Our ref: NO/2021/113242/02-L01
Your ref: Oakmere Accrington Road

Date: 30 July 2021

**FLOOD MODEL RUNS APPRAISAL COMMENTS REQUESTED LAND OFF
ACCRINGTON ROAD, WHALLEY, BB7 9TB**

We have reviewed the model summary Technical Note supplied by JBA, reference 2021s0600, rev.0001, June 2021 and we have the following comments.

COMPENSATORY STORAGE SECTIONS

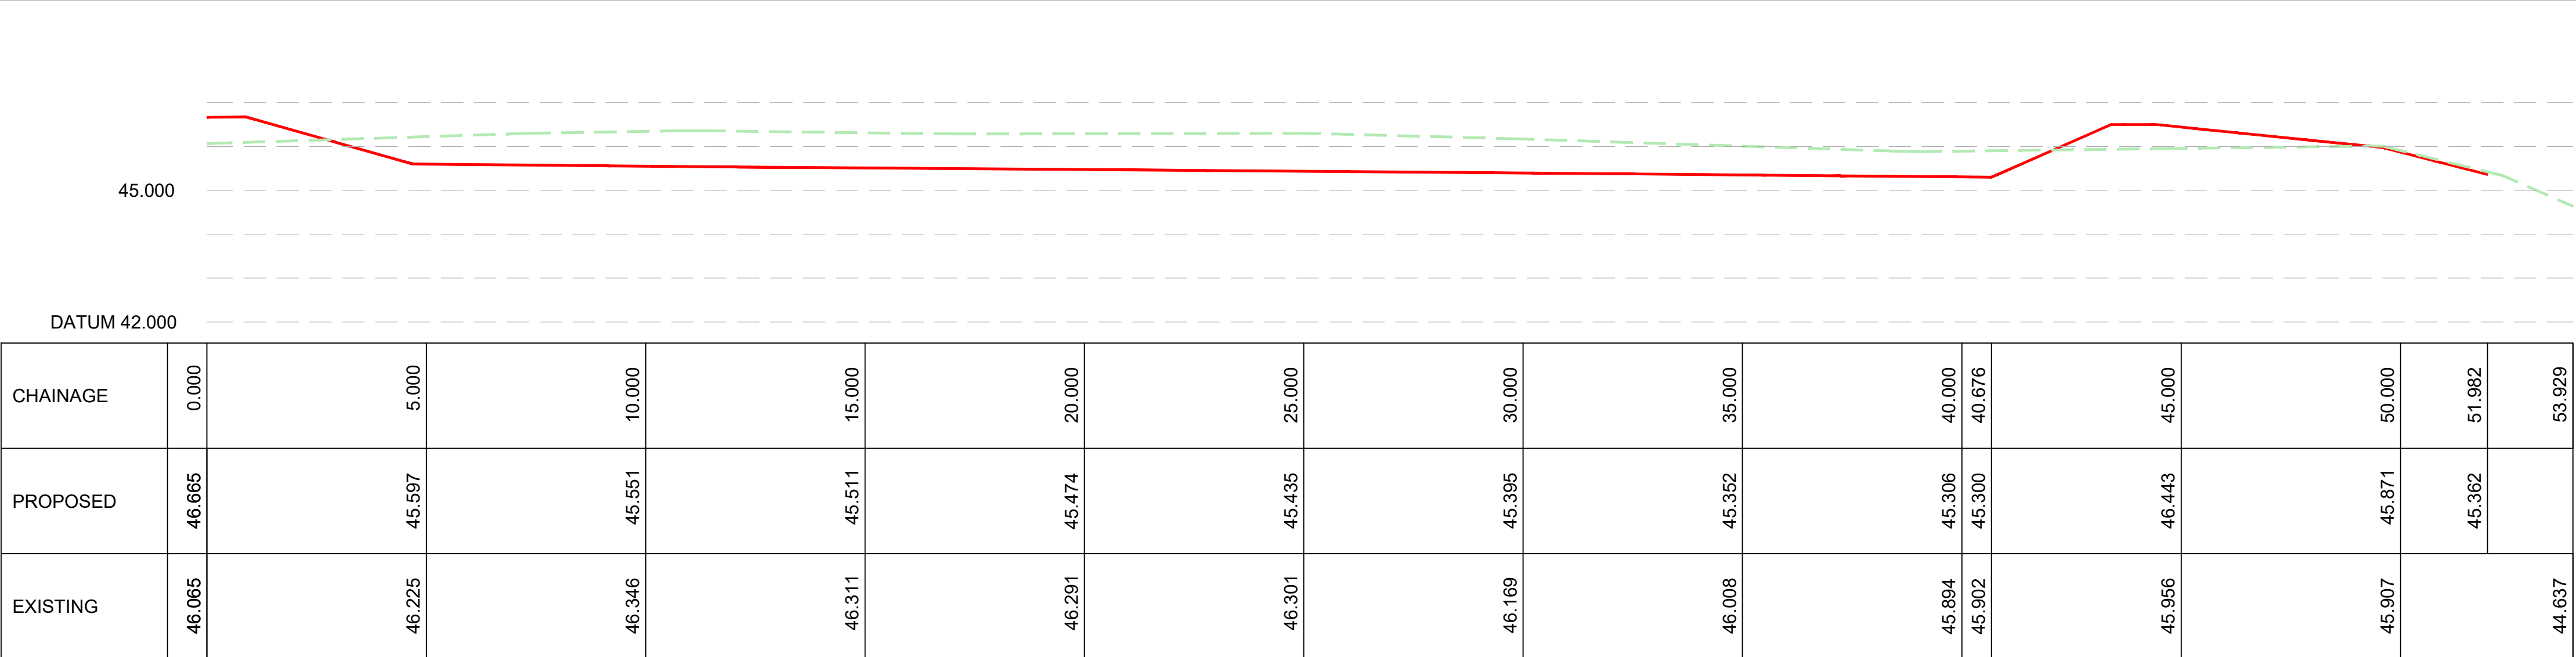
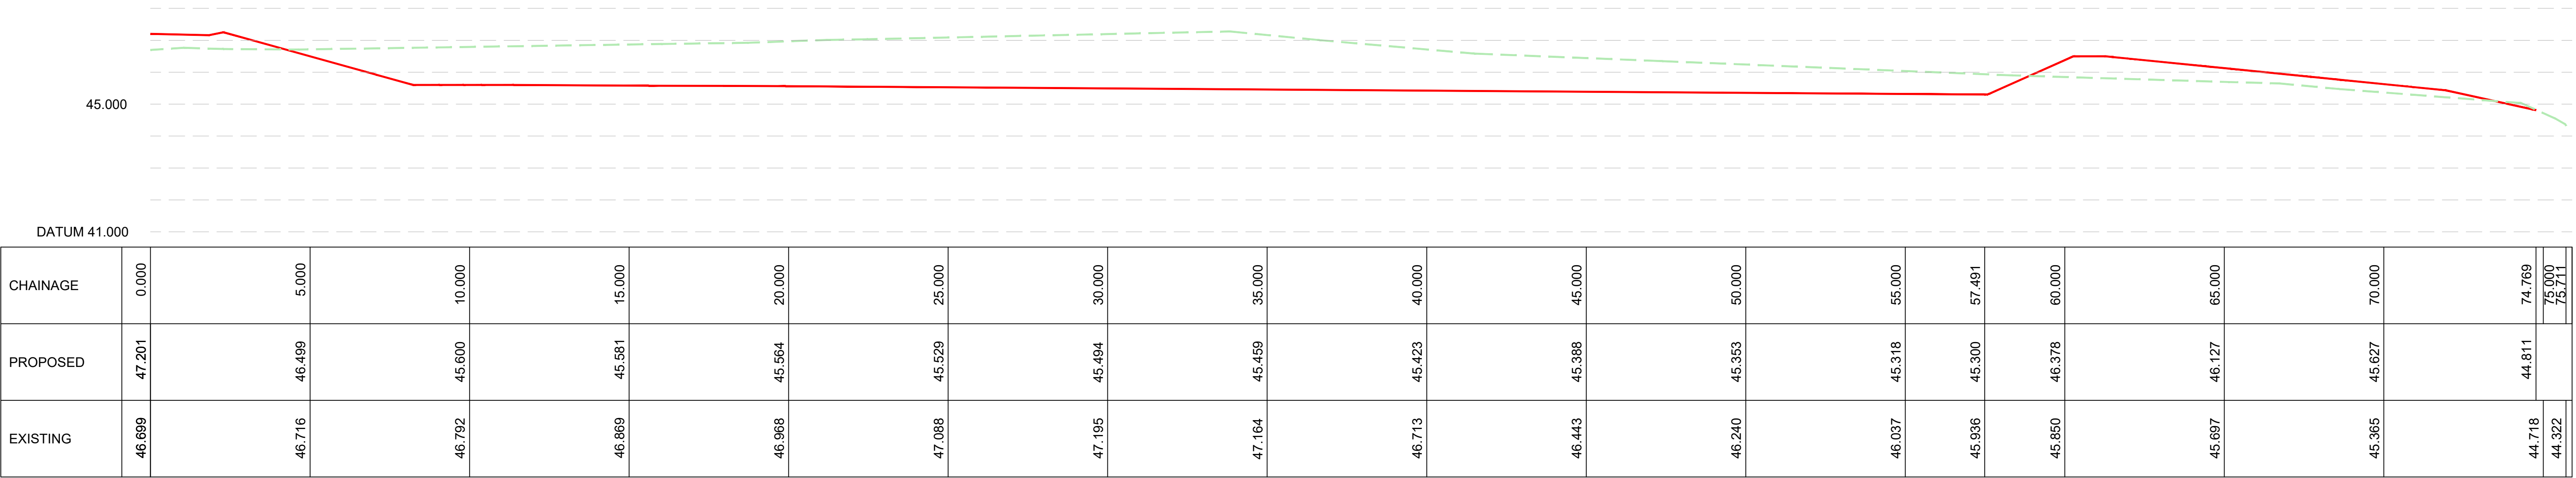
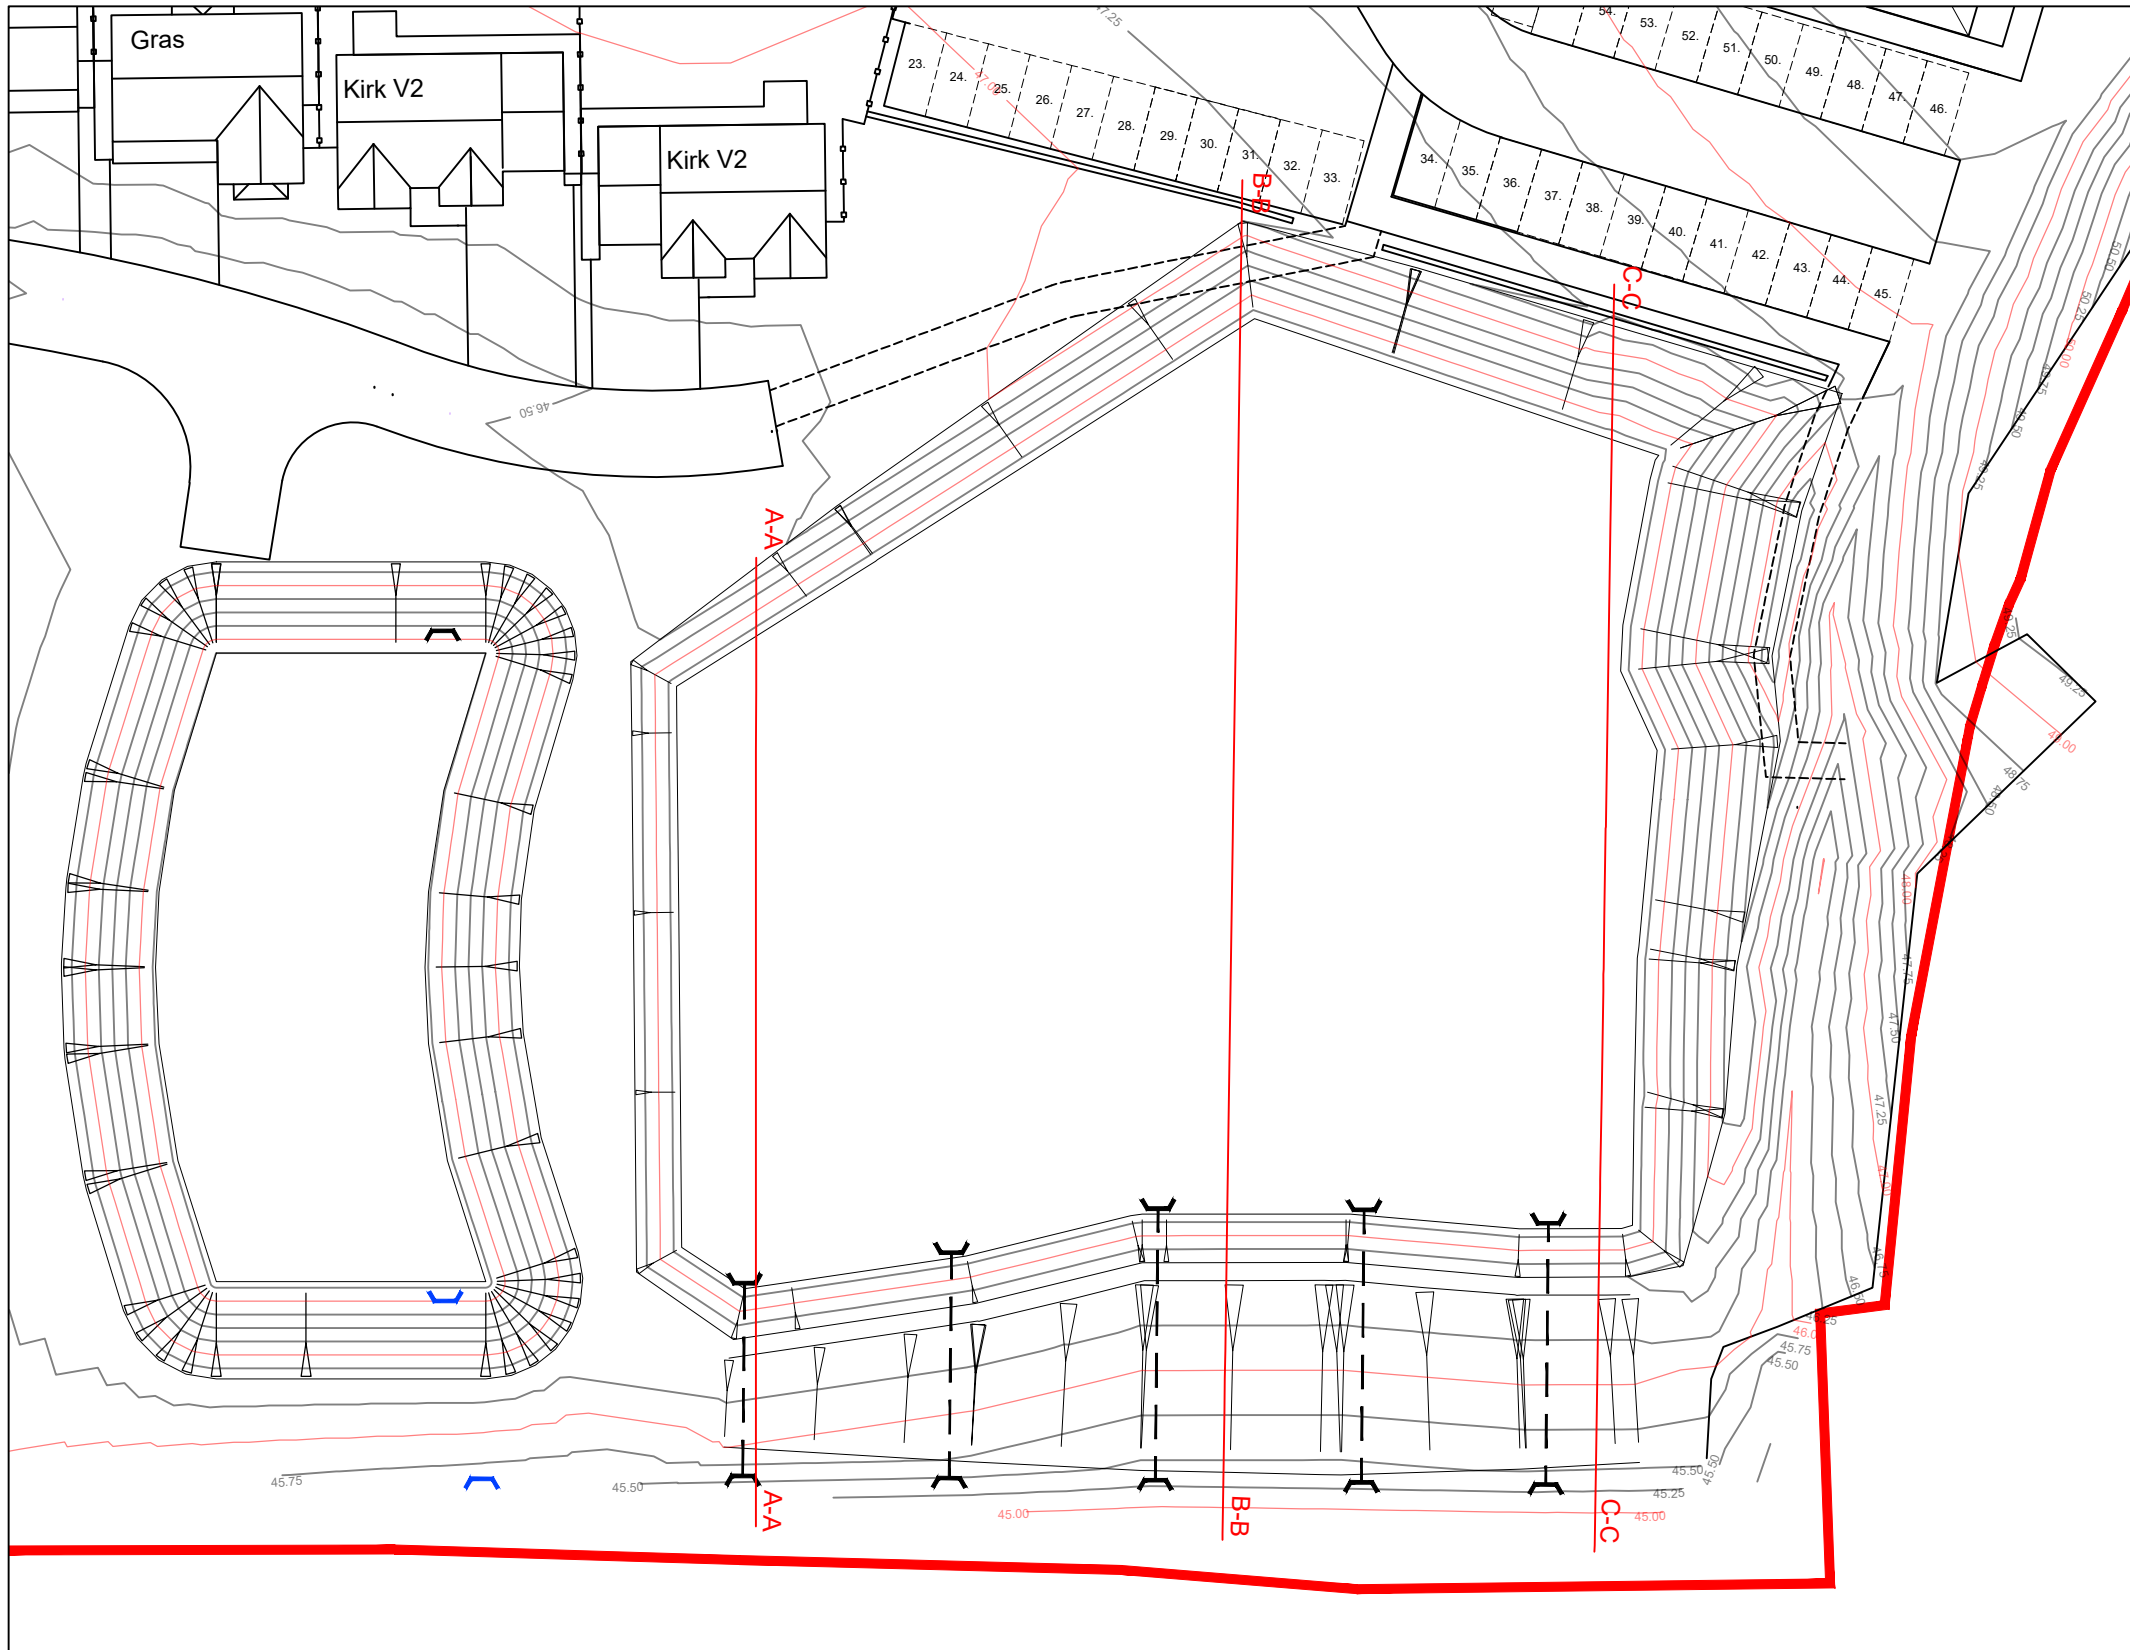
The modelling has shown that the modelled ground level changes are unlikely to increase flood risk elsewhere, as such, the ground level alterations are considered to be acceptable in principle. When submitted to planning, please provide more detail on the proposed ground levels of the compensatory storage scheme and over the site as a whole. It is expected that the proposed levels in the planning application will reflect the levels inputted into the model.

In our assessment at planning, we will want to see that the compensatory storage area will;

- Act as part of the flood plain. This means it should freely fill during and then drain after a flood event.
- We will also want to see that surface water will not pond in the area which could reduce the capacity to store fluvial flood water. Information has not been provided at present to confirm this, but the submission of the proposed ground levels (i.e. to see the slope of the ground), FRA and Technical Note should be sufficient to assess this
